**Re: Residential Development at 52 – 58 Walker Street, Rhodes MP10_0058
and DA 342/2010**

This response from Sydney South West Area Health Service (SSWAHS) is in relation to the Environmental Assessment Exhibition for the proposed residential development at 52 – 58 Walker Street, Rhodes.

Major Project Application MP10_0058 and DA 342/2010 – Residential Development at 52-58 Walker Street Rhodes

TRAFFIC CONTROLS

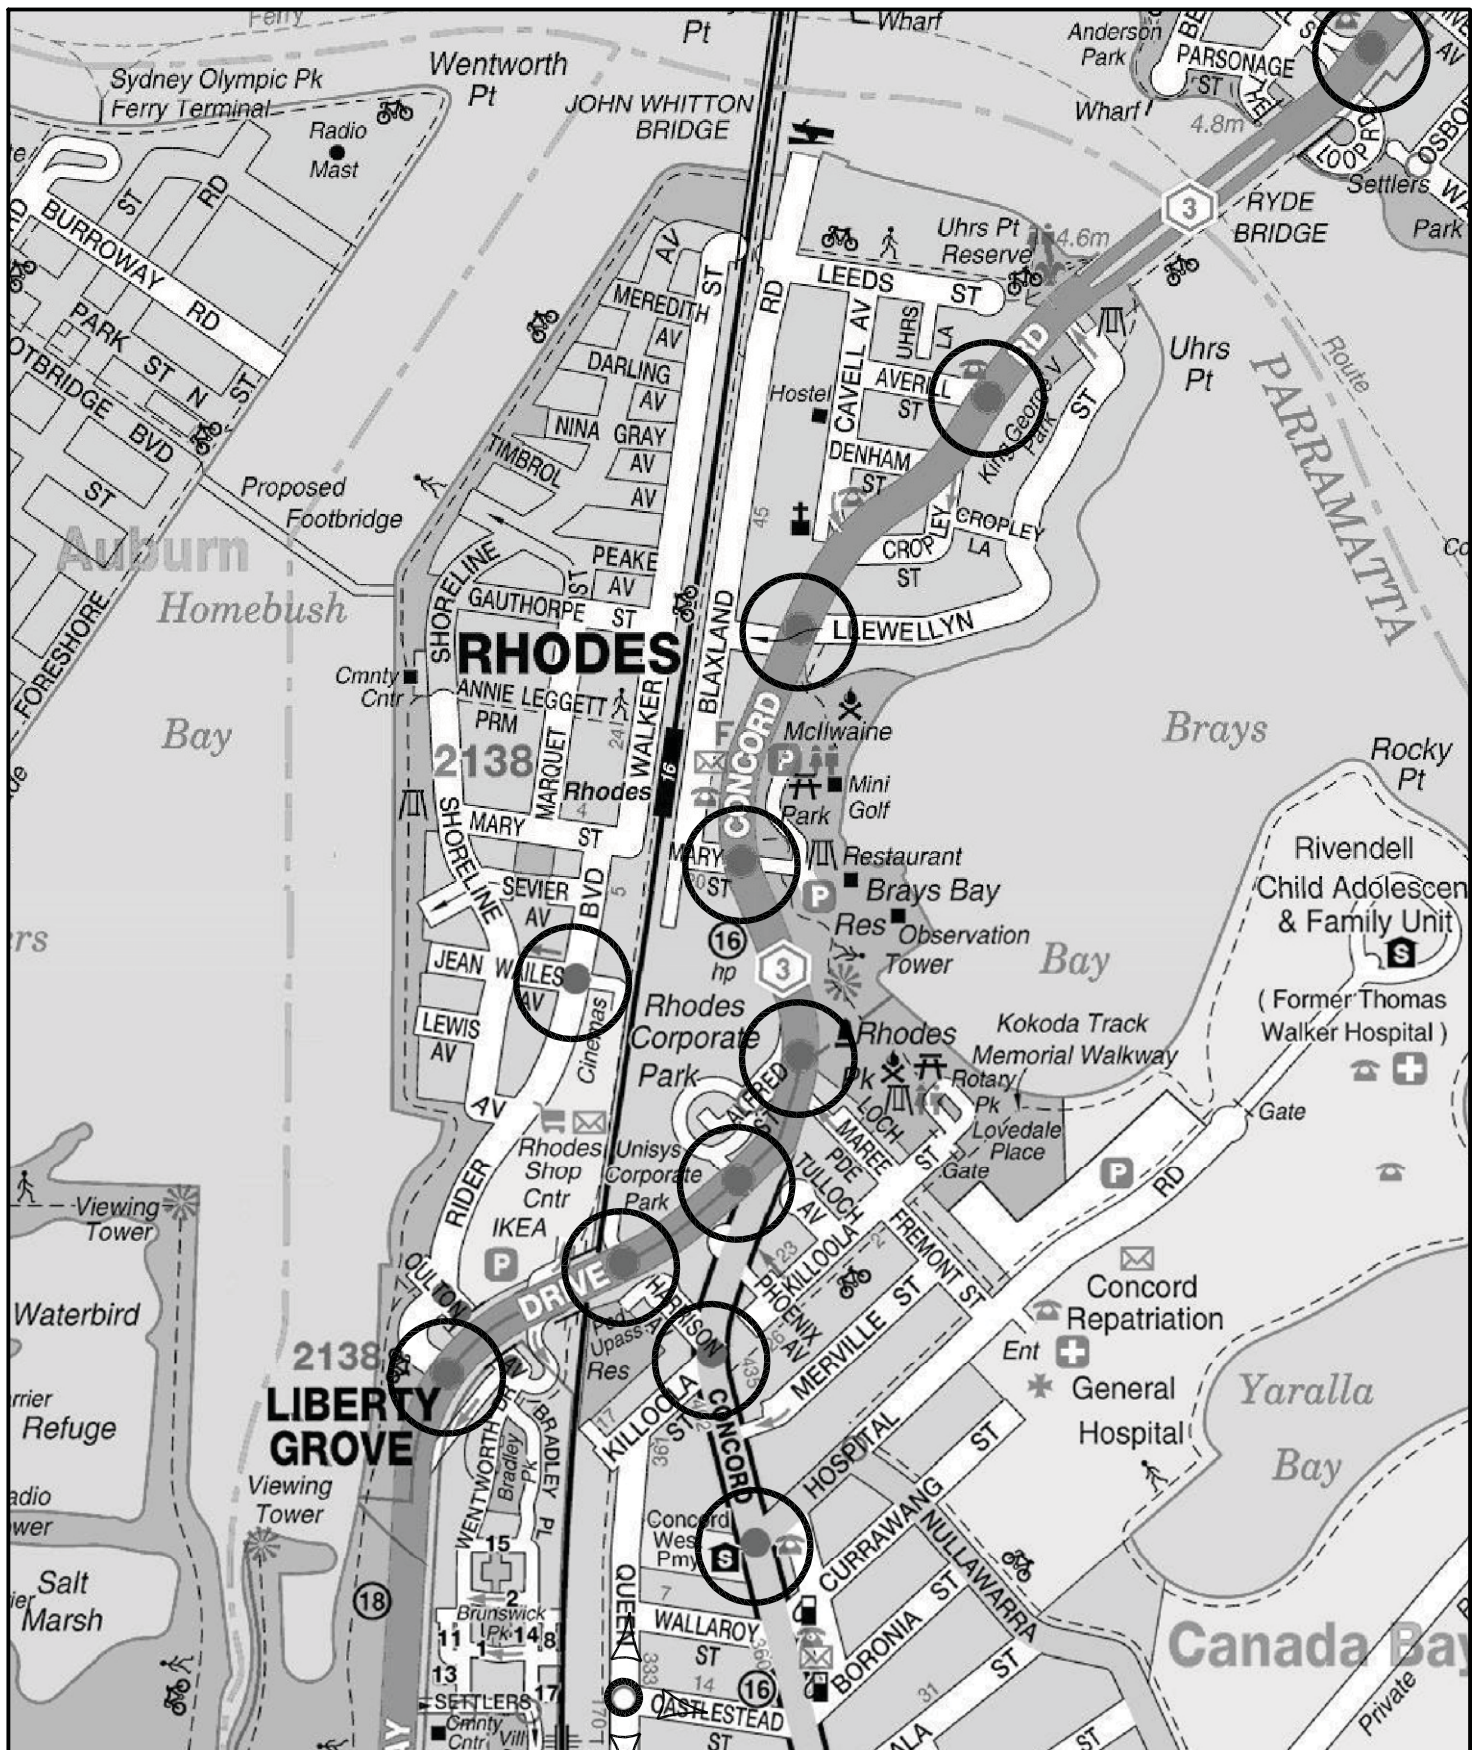
2. The traffic modeling of the intersections in the Assessment of Traffic and Parking Implications Report dated May 2010 (Ref No: 10068) is unacceptable. In the report, it shows that all the existing intersections operate above LOS C, which doesn't match with the reality where some intersections are now operating under pressure during peak hours. The report also doesn't include some critical intersections such as the Homebush Bay Drive/Concord Road intersection.

Based on the above comments, a revised traffic impact assessment report shall be submitted to the RTA for review and approval. The report shall evaluate the cumulative traffic impact of the proposed 583 development units, the retail component and the associated child care centre together with the all other developments within the Rhodes Peninsula area by using a Strategic Traffic Model.

PRELIMINARY
 LANDSCAPE PLAN
 Scale: 1:200 @ B1
 Drawing Number: 101 E

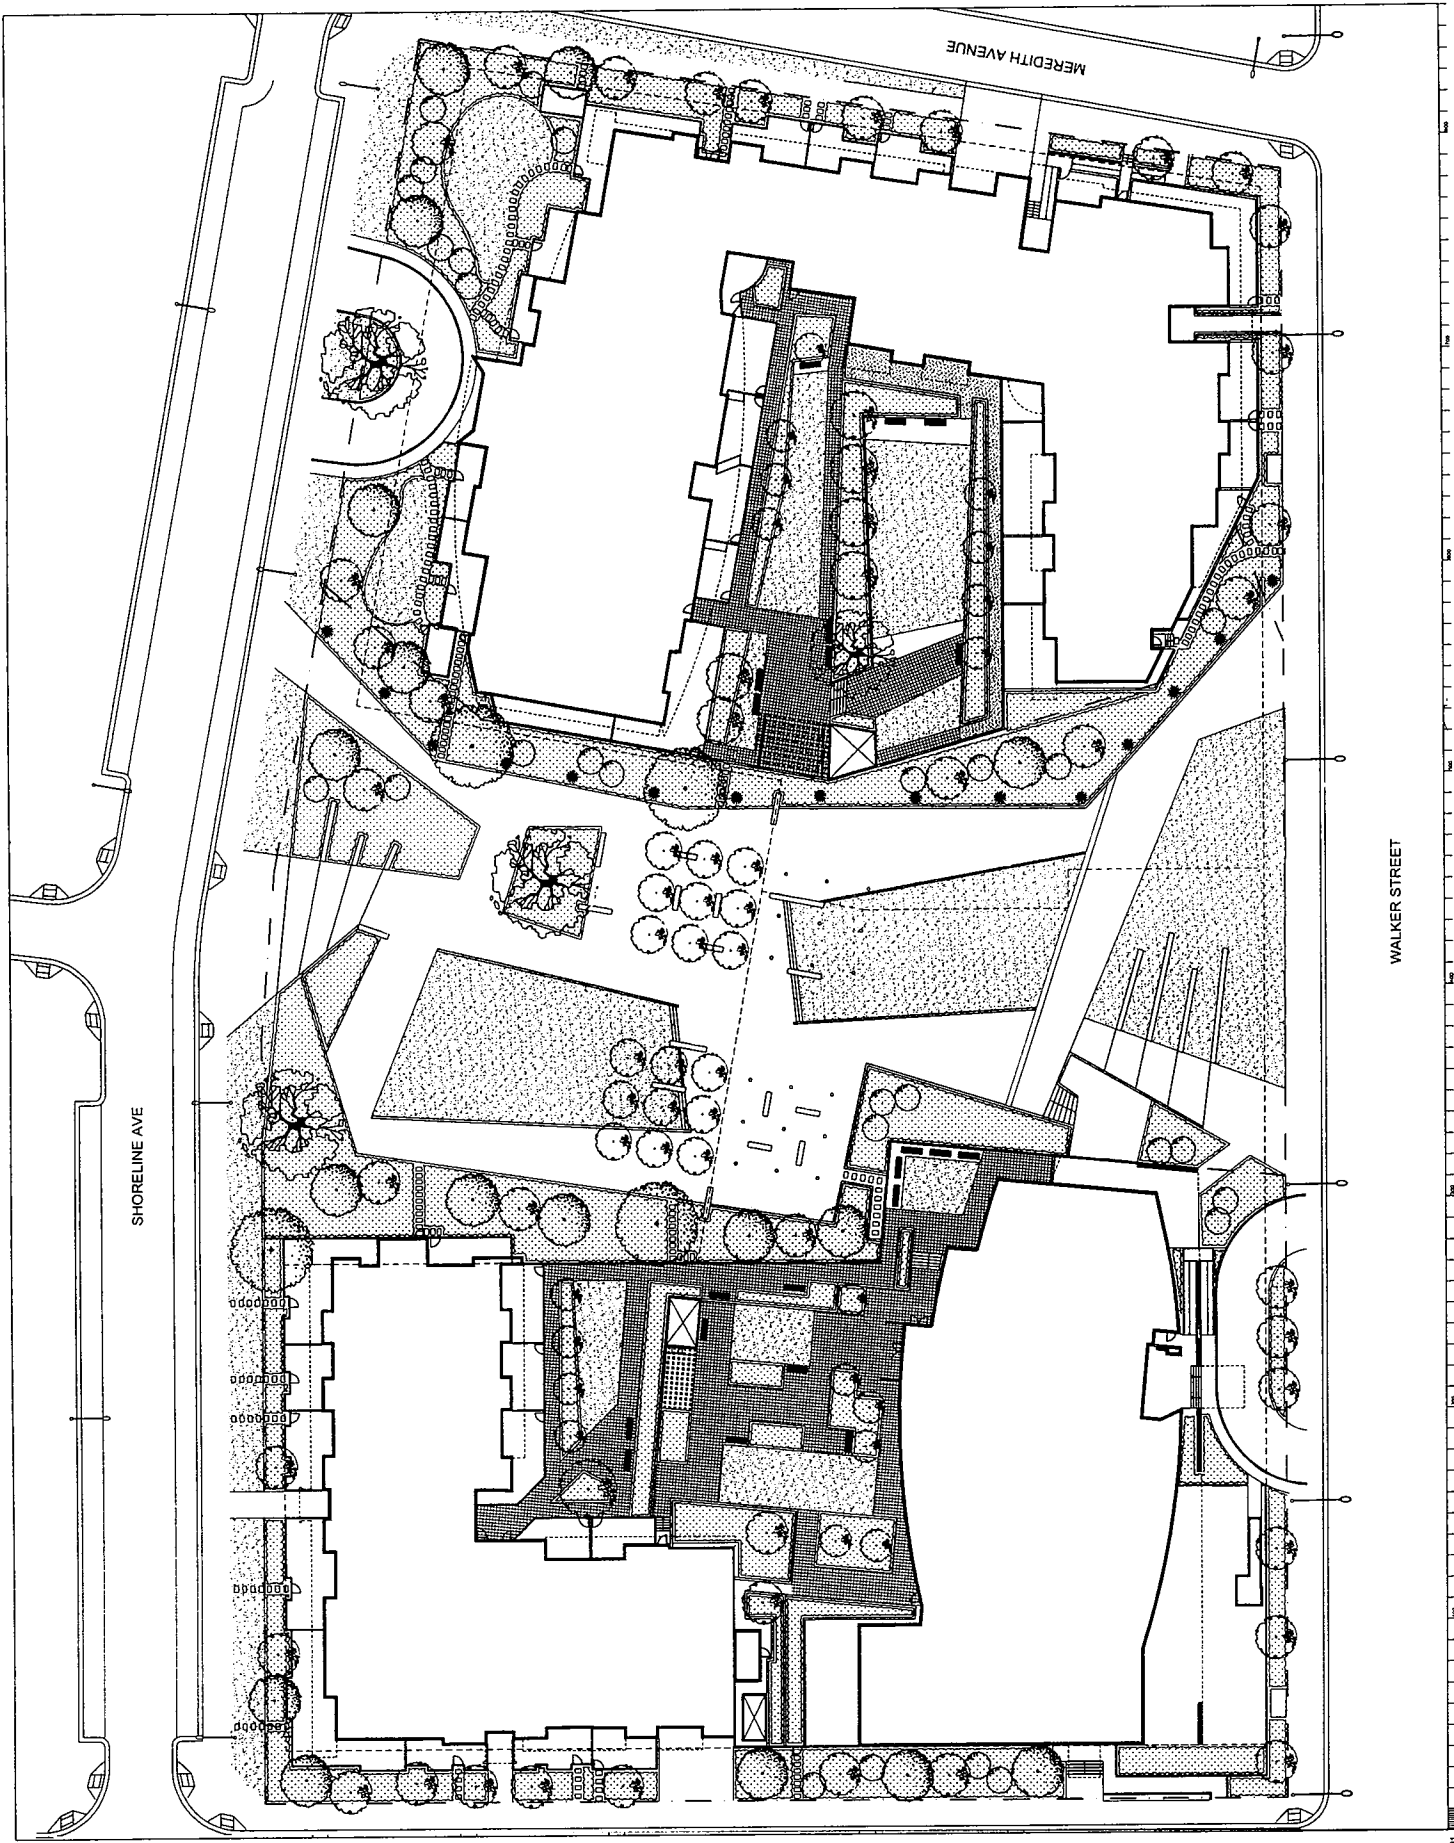
It is commendable that a large area (4,600 sq. m) of open space has been planned, and that the foreshore area is to be publicly accessible. However, it is not clear that the park will be designed to encourage a range of user groups. Proximity to the units alone may not be enough to encourage or facilitate a range of uses. The park should be designed to maximise usage as this creates opportunities for social interaction and improves safety.

It would also be preferable to incorporate a variety of open spaces of different sizes, in different locations for different purposes to encourage people to use public space. The focus on one large park may not be sufficient for this purpose.
